From: Amanda Scholes on behalf of Planning.Responses
Sent: 05 December 2019 08:59
To: Planning Scanning
Subject: FW: Discharge of Drainage Conditions - LU/337/19/DOC - CM Wood Body Repair Centre

From: Sarah Burrow [REDACTED]
Sent: 04 December 2019 17:34
To: Anita Gardner [REDACTED]
Cc: Planning.Responses [REDACTED]
Subject: RE: Discharge of Drainage Conditions - LU/337/19/DOC - CM Wood Body Repair Centre

DRAWING TITLE
SOAKAWAY DESIGN ALTERNATIVE TO PERMEABLE PAVED INFILTRATION SYSTEM

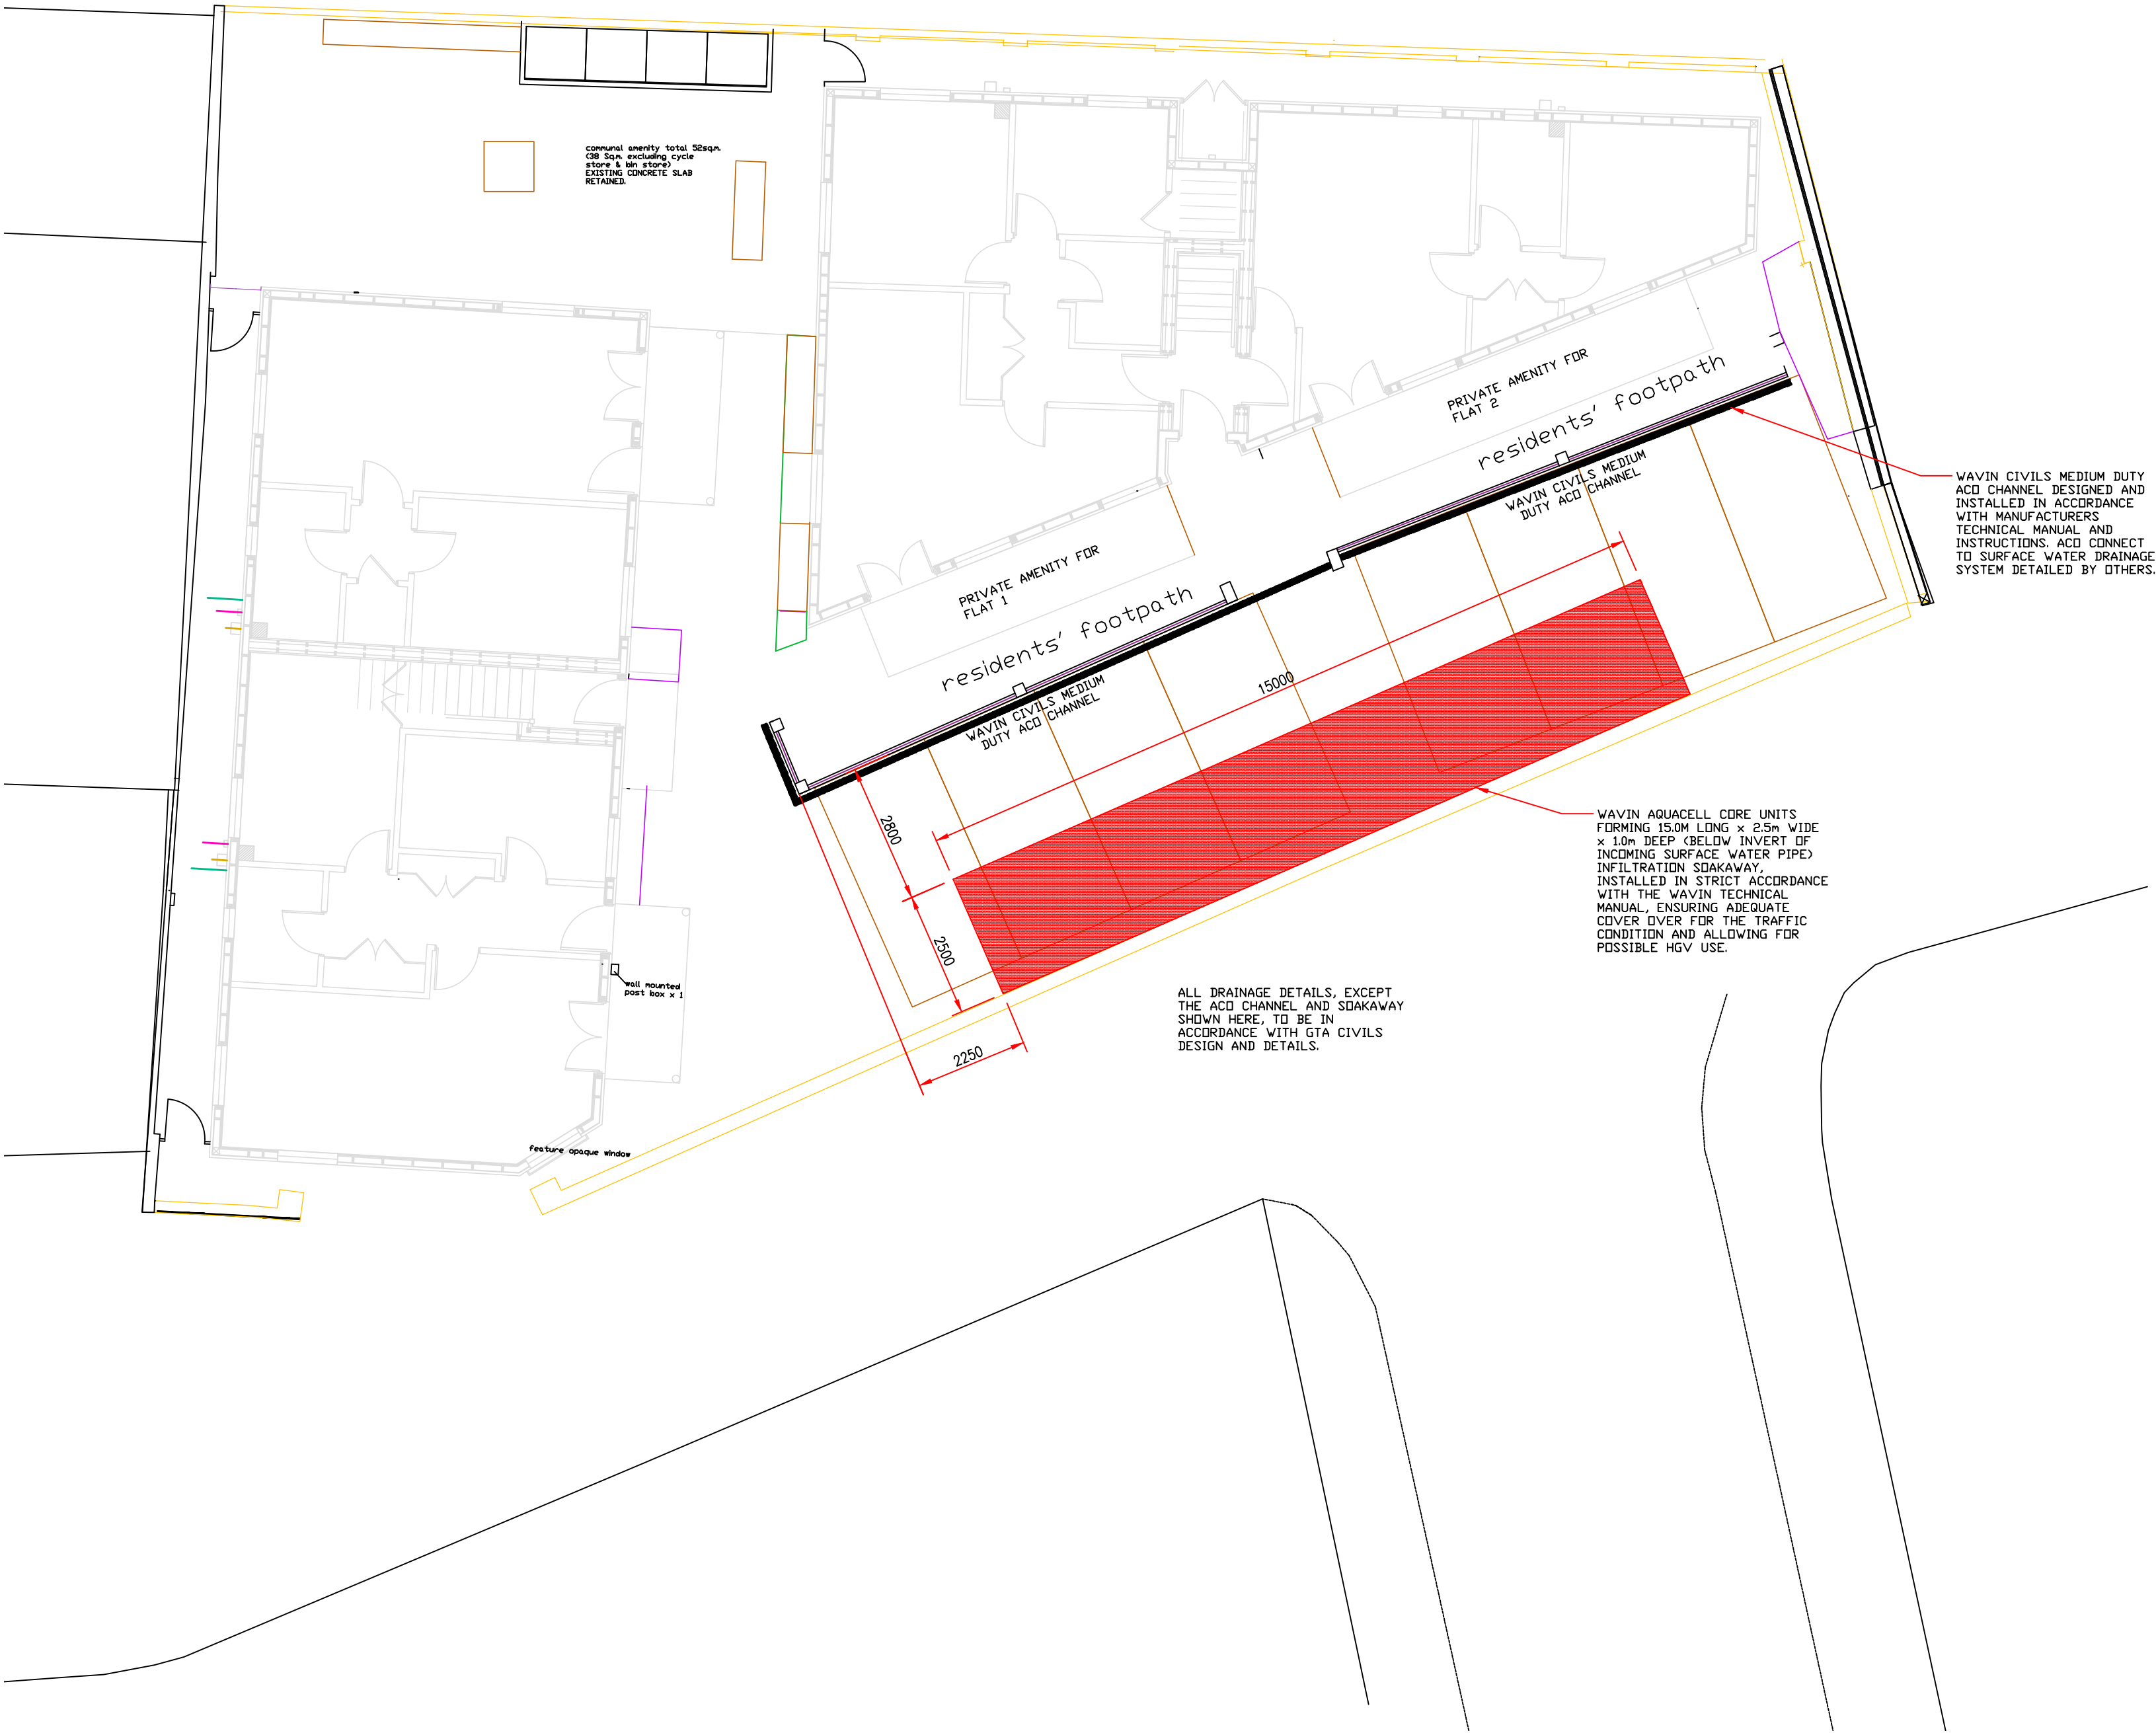
1. Please provide details of infiltration testing and groundwater monitoring. Including the depth that the infiltration tests were completed to. The proposed soakaway is deeper than the agreed permeable paving.
2. Please submit drawing details for the soakaway and ACO channel, including the appropriate cover depths and levels.
3. Please include the location of pipes and manholes on the Drainage Layout, please label these with their diameters, materials, cover levels, invert levels and falls as appropriate.
4. The calculations have confused the dimensions of the soakaway. The depth is 1m (1000mm) rather than 14776mm. Please adjust accordingly.
5. Please add 40% allowance for climate change.
6. Please provide silt traps upstream of the connection to the soakaway and show these on the drainage layout.

SOAKAWAY DESIGN ALTERNATIVE TO PERMEABLE PAVED INFILTRATION SYSTEM

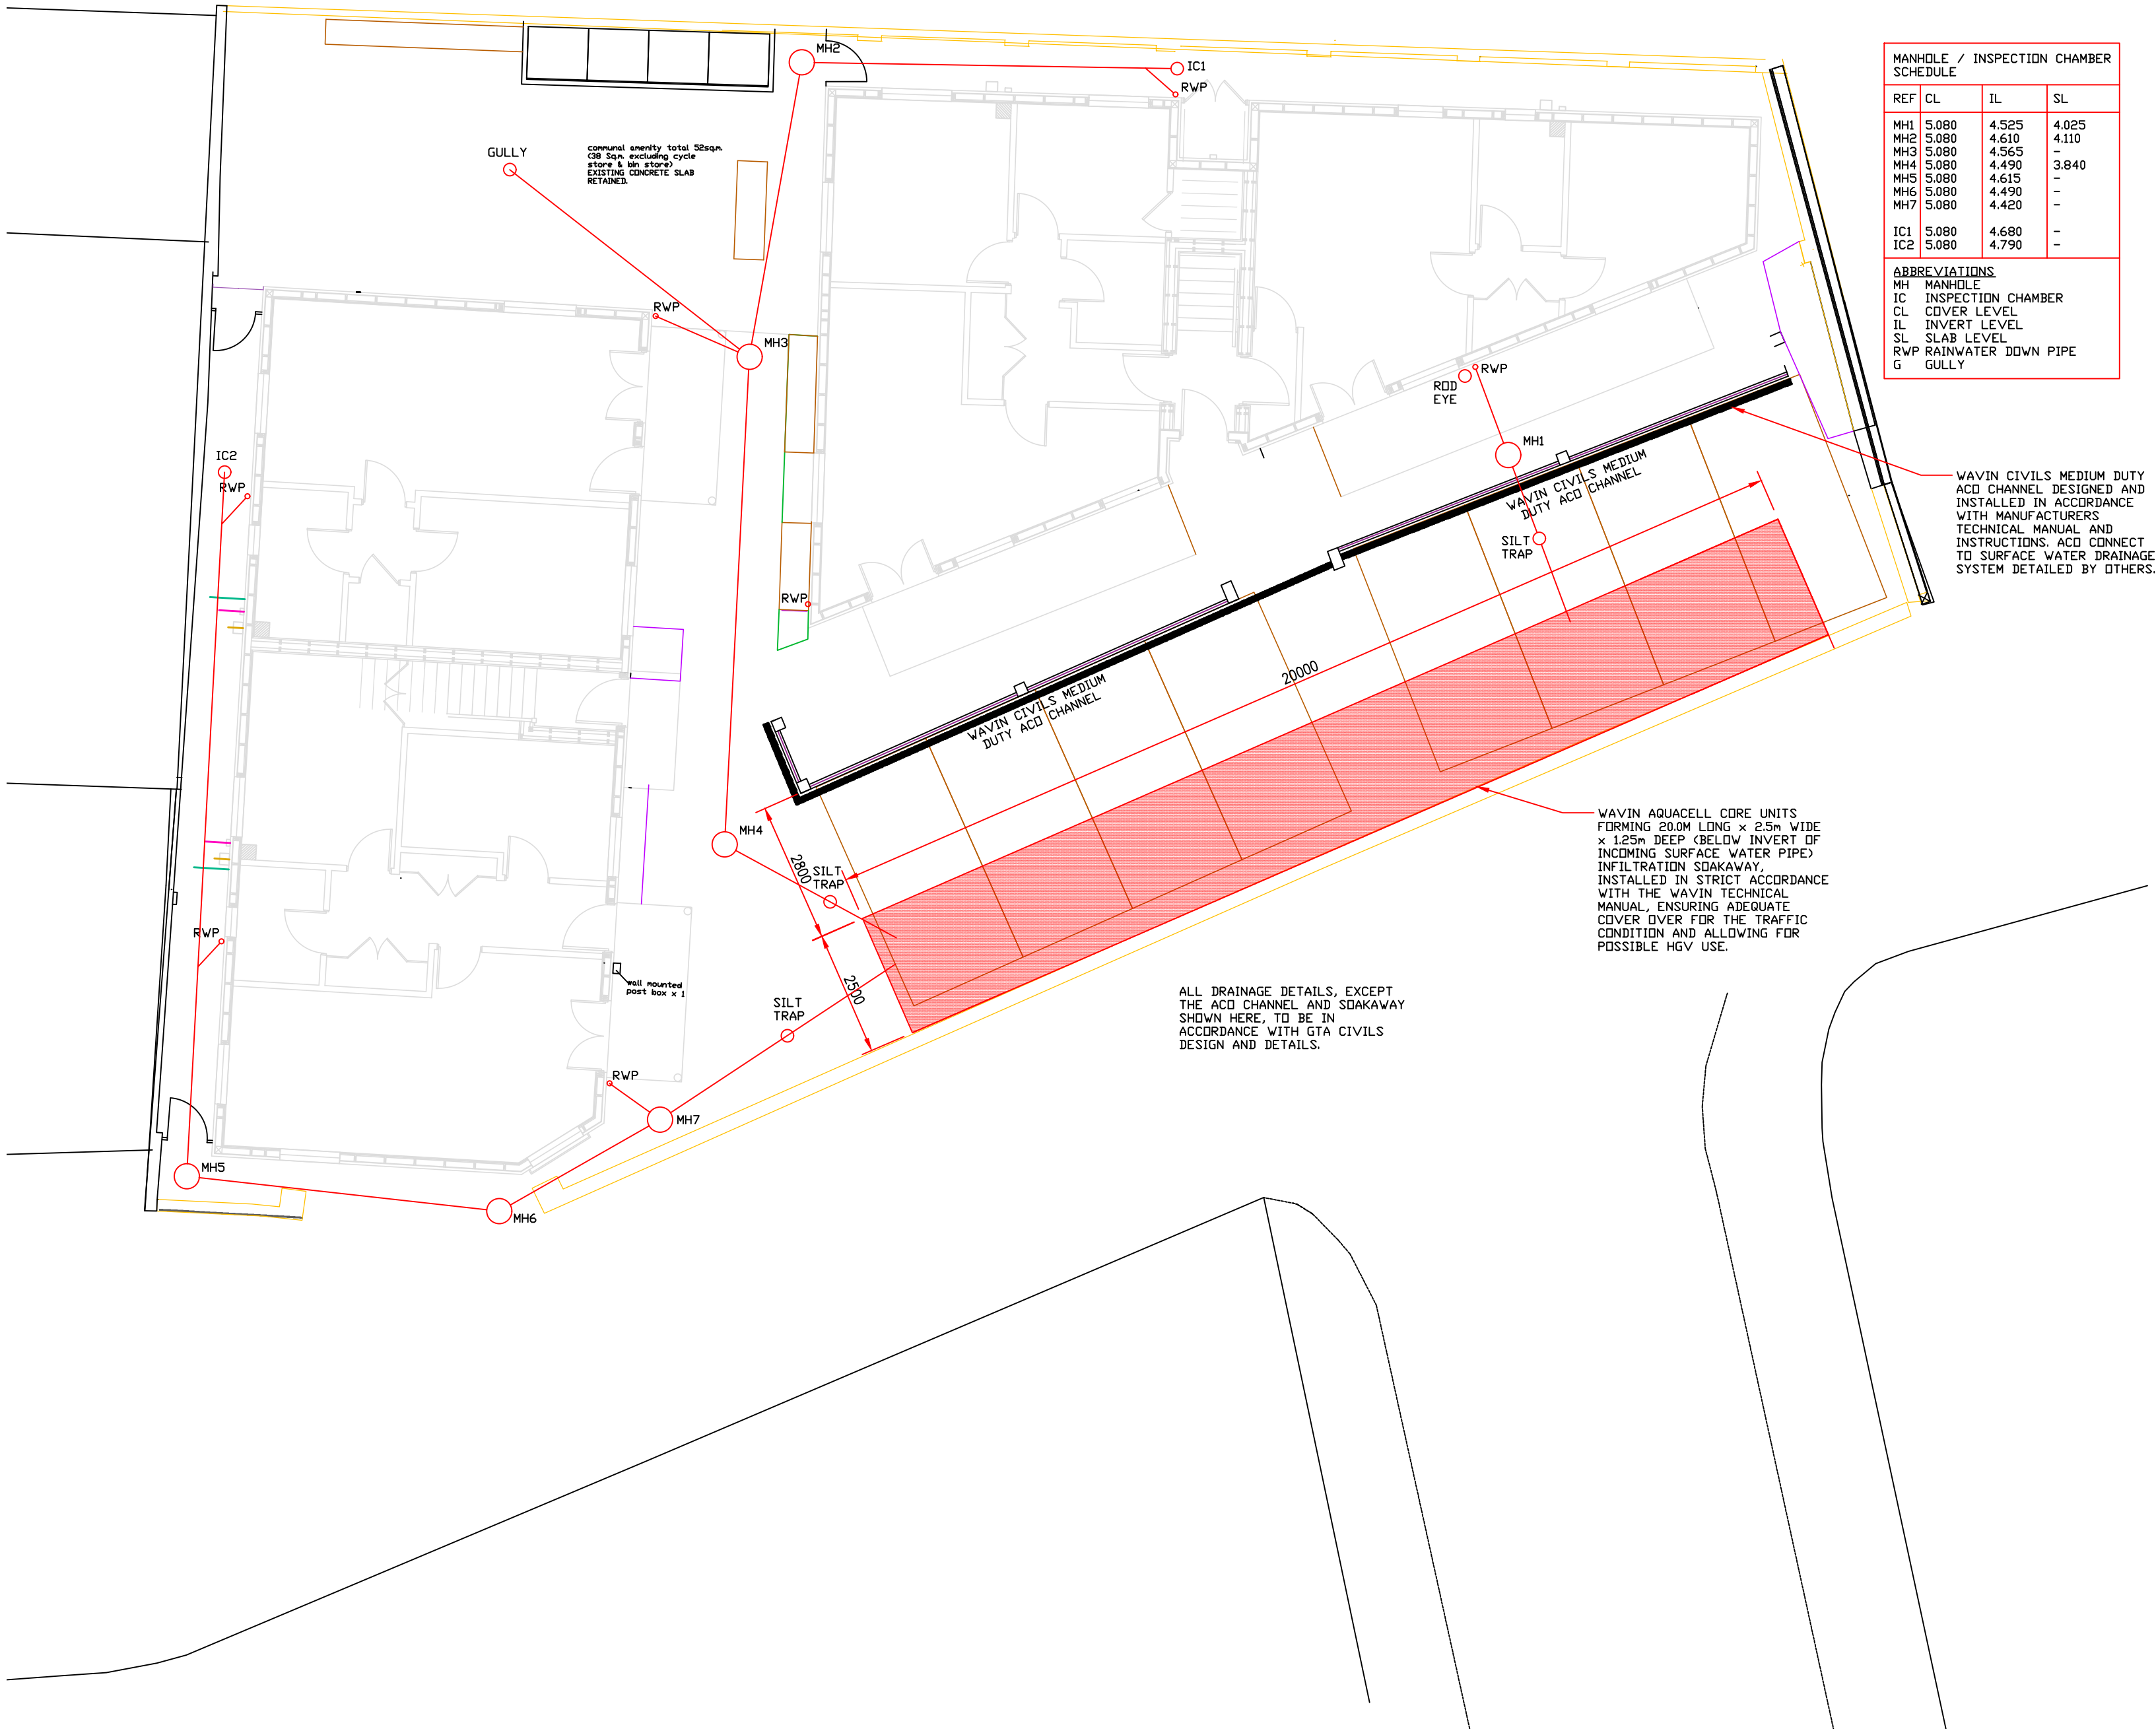
2. Please submit drawing details for the soakaway and ACO channel, including the appropriate cover depths and levels. We have these in plan but also require cross section. Please also add the invert levels of the pipes entering the soakaway and the soakaway invert level and/or the level of the top of the soakaway.

3. Please include the location of pipes and manholes on the Drainage Layout, please label these with their diameters, materials, cover levels, invert levels and falls as appropriate. Still need pipe diameters and materials.

4. The calculations have confused the dimensions of the soakaway. The depth is 1m (1000mm) rather than 14776mm. Please adjust accordingly. Done
5. Please add 40% allowance for climate change. Still set to 30% however there is more than enough capacity to compensate (on basis of infiltration rate which will change).

6. Please provide silt traps upstream of the connection to the soakaway and show these on the drainage layout. Done
